12 October 2012

**The Able Marine Energy Park Development Consent Order 2012 - 'Comments on responses to the Examining Authority's second round of written questions'**

## **Annex 2: Updates on progress in relation to the MMO's comments made in the Statement of Common Ground on the Environmental Statement, Final Version dated 27 July 2012**

Figure 6 Model layout and bathymetry (with AMEP scheme) also showing locations of E.ON and Centrica intakes and outfalls

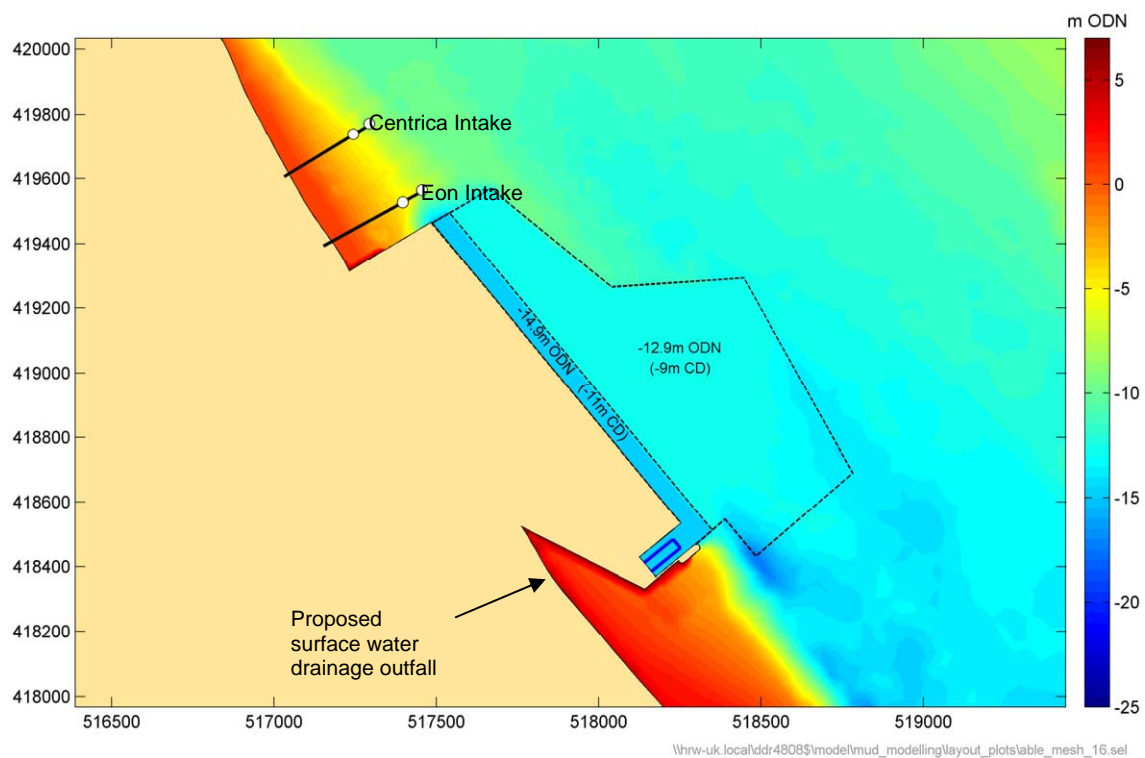
- Clarification is sought as to what the Applicant intends to do with regards to the EON and Centrica outfalls. The MMO understands that either the outfalls will be re-located or they will require dredging; the deemed marine licence must accurately reflect the works to take place.

12.6.9 The MMO requests that the applicant clarify whether the EON and Centrica outfalls will be re-located or managed through dredging.

**Able 9.10.12:** DML is to include for plough dredging of the areas adjacent to the outfall pipes.

**Able 9.10.12:** Managed through dredging.
